June 15, 2015

**RE: HLP Endodontics, 10429 Lagrima Del Oro NE
Grading and Drainage Plan
Engineer's Stamp Dated 6-03-15 (File: F21-D063)**

SECTION B-B NTS

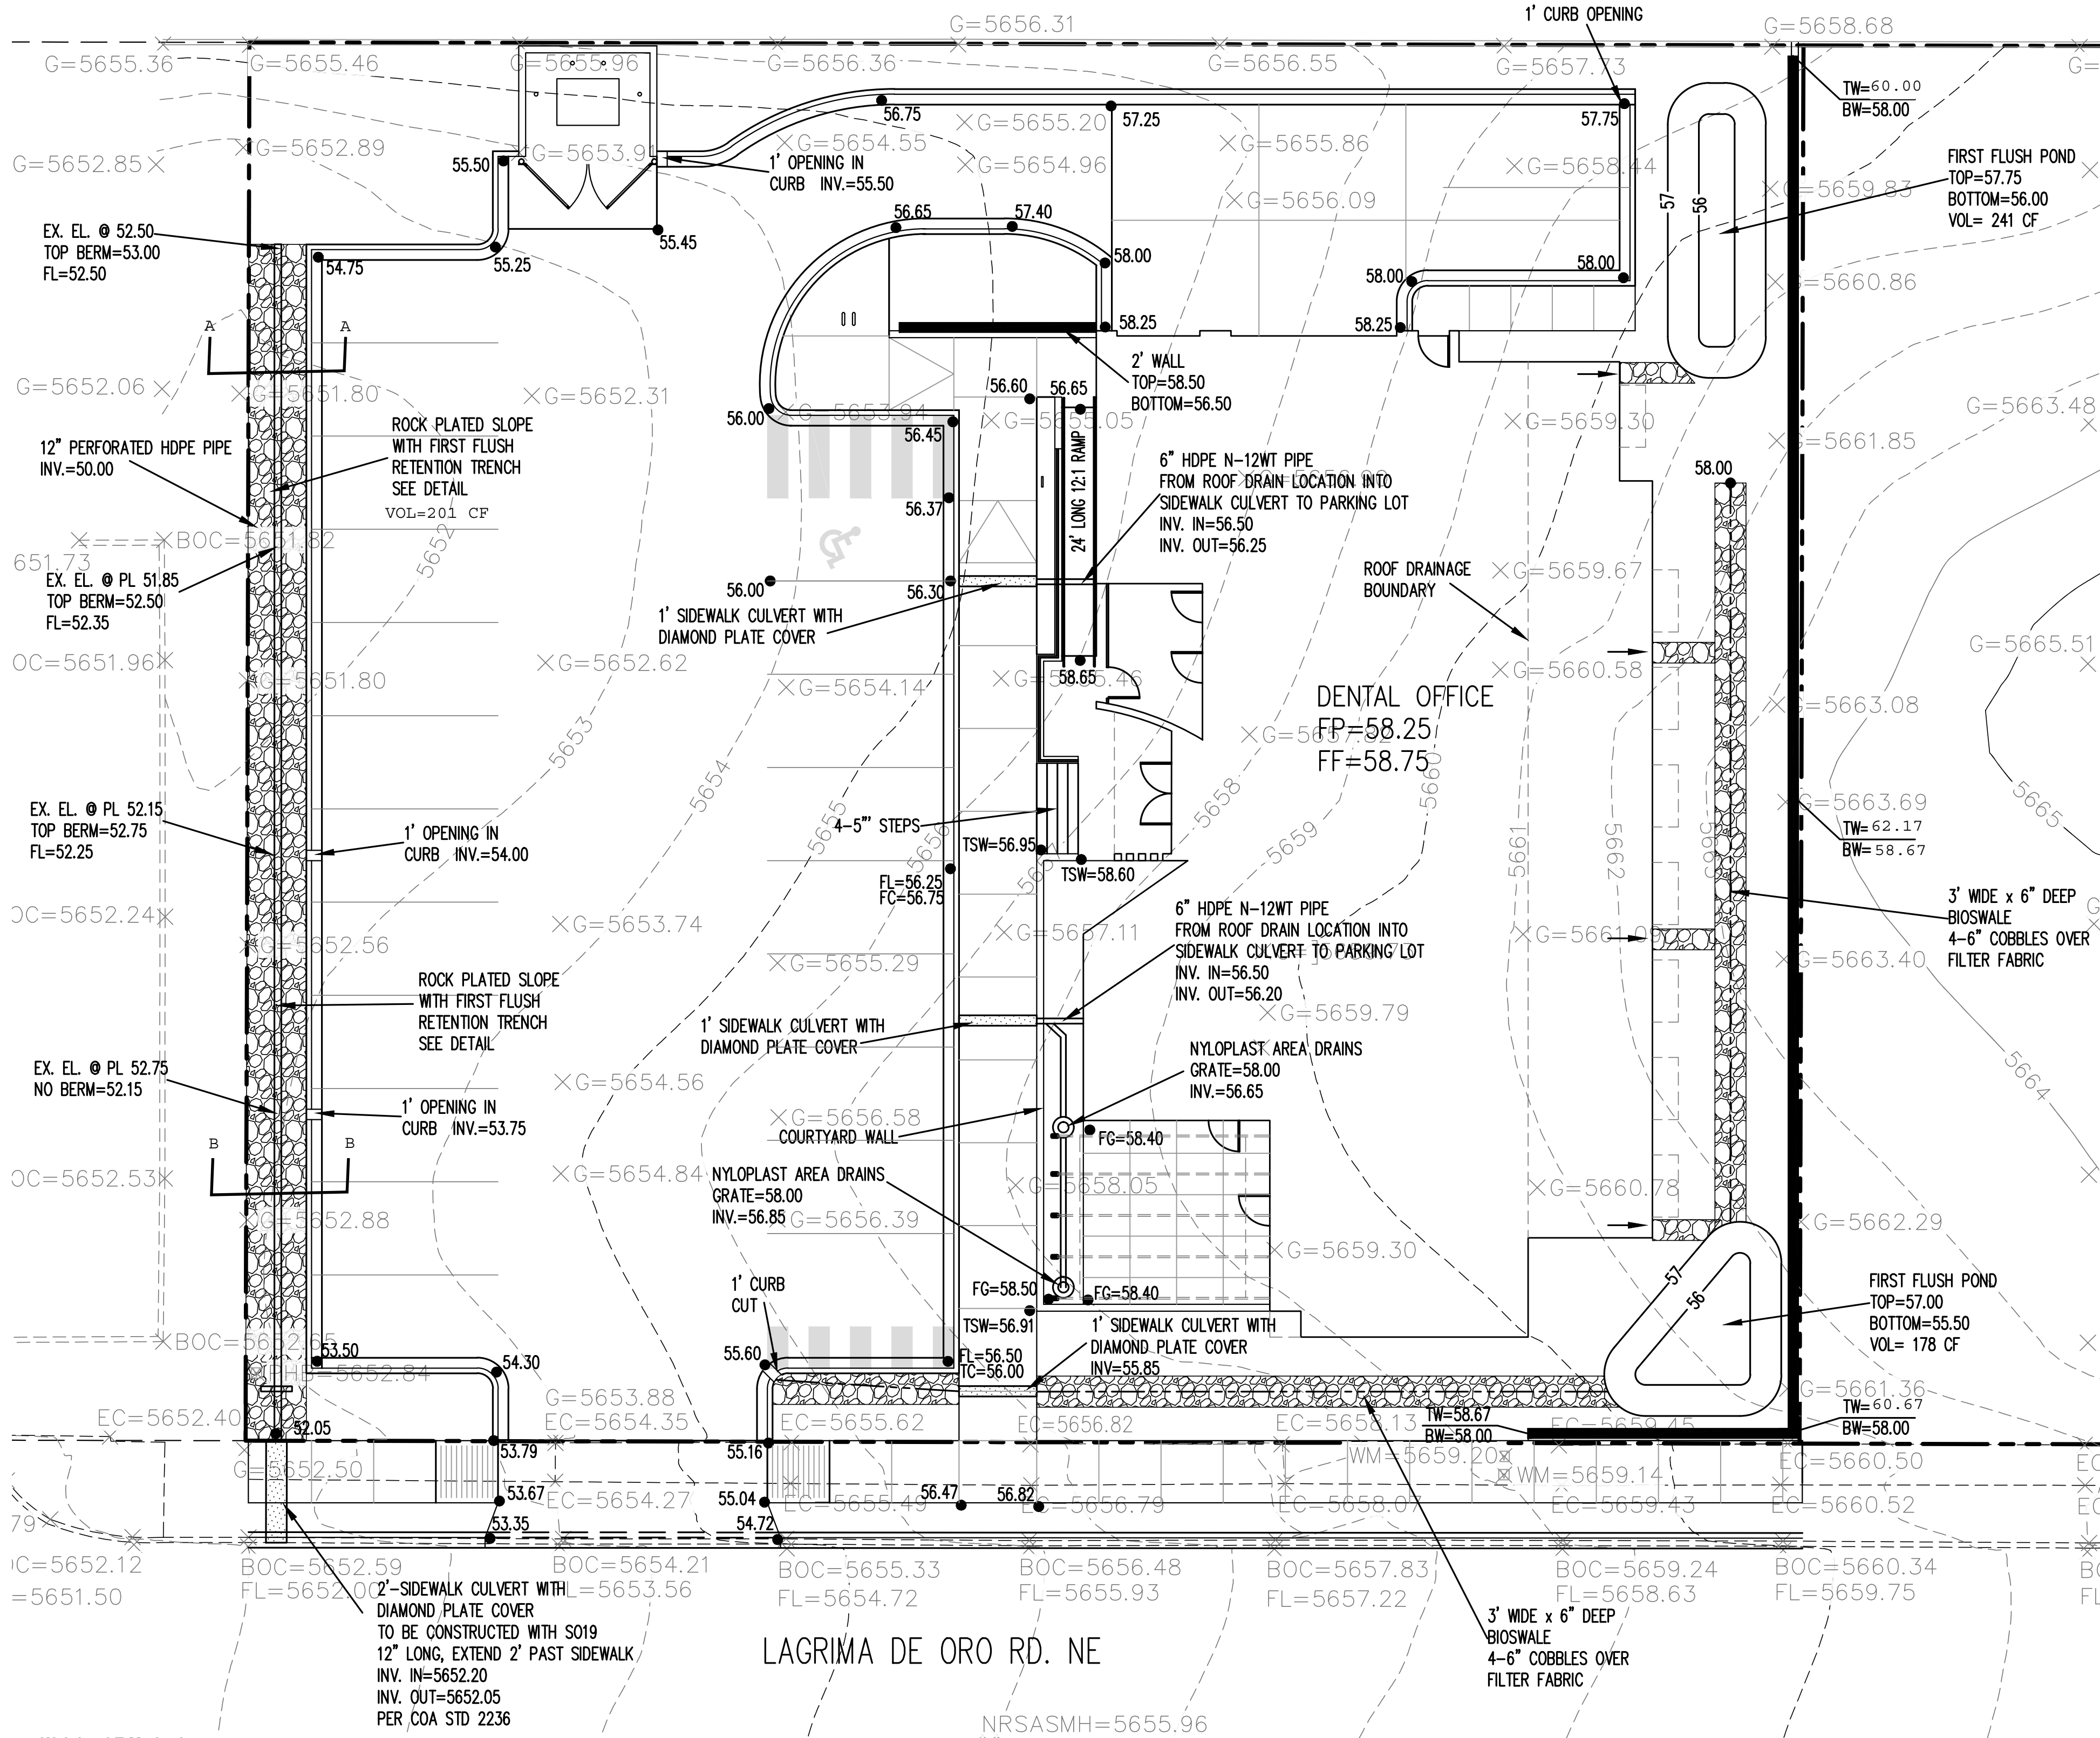
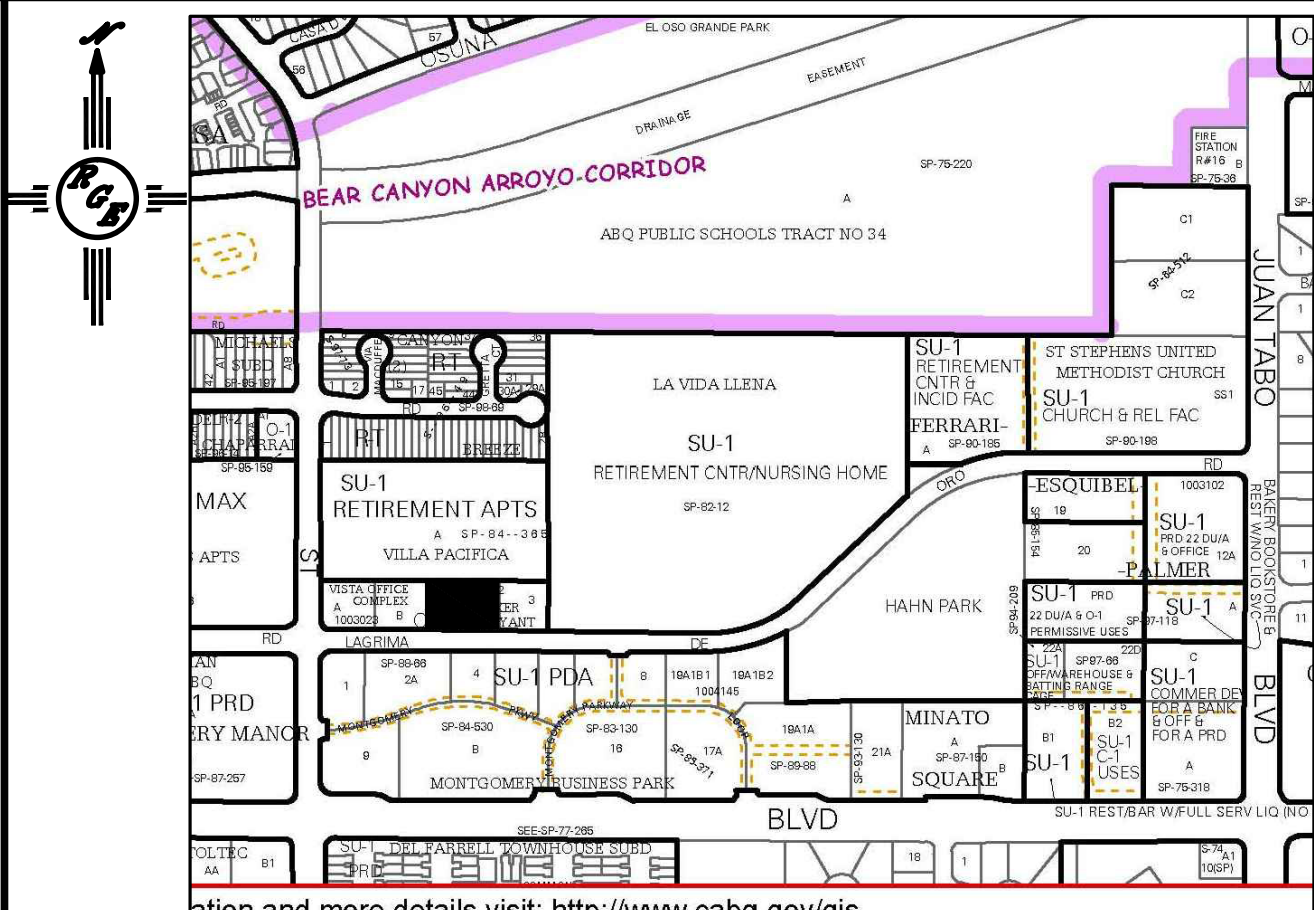
- 1) The swale along the west property line is listed as 1 foot deep with a 6-inch check dam. The middle elevation shown only has a difference in elevation of 0.5 feet between berm and flowline. The invert elevations for the sidewalk culverts also appear to be 30 feet too low from what the elevations are intended to be. Revise as needed, and provide slope of swale as applicable. On cross-section A-A, it would be helpful to show the one foot depth and the 6-inch check dams that are installed every 30 feet. If the check dams are 30 feet apart, label them as such. Also provide the flowline elevations at each of the curb cuts along the west edge of the parking lot. Show the relationship between the curb cut elevation and depth of swale to ensure drainage to swale. Provide riprap for the short distance from the curb cut to the rock swale.

- 2) Reference COA Standard Drawing 2236 for the construction of the sidewalk culvert.
- 3) Approximately 10% of the site drains to the first flush ponds on the east side as indicated by the roof drainage boundary. An insufficient percentage of the first flush volume is provided along the west side even though this is where the vast majority of the site drains. Is there opportunity to provide first flush volumes within the landscaped areas at the northwest and southwest corners of the site?

- 4) Where it says "Volume – 24 cf per dam", add language indicating that this is for the "first flush", and provide the total volume for the first flush within this area.

- 5) On cross-section A-A along the west property boundary, the slope to the west of the berm be called out as 3:1 since it is right along the property boundary without protection.

6) Call out depth of 4-6" cobble within the bioswale.

7) The referenced detail sheet in the letter also needs to be provided.
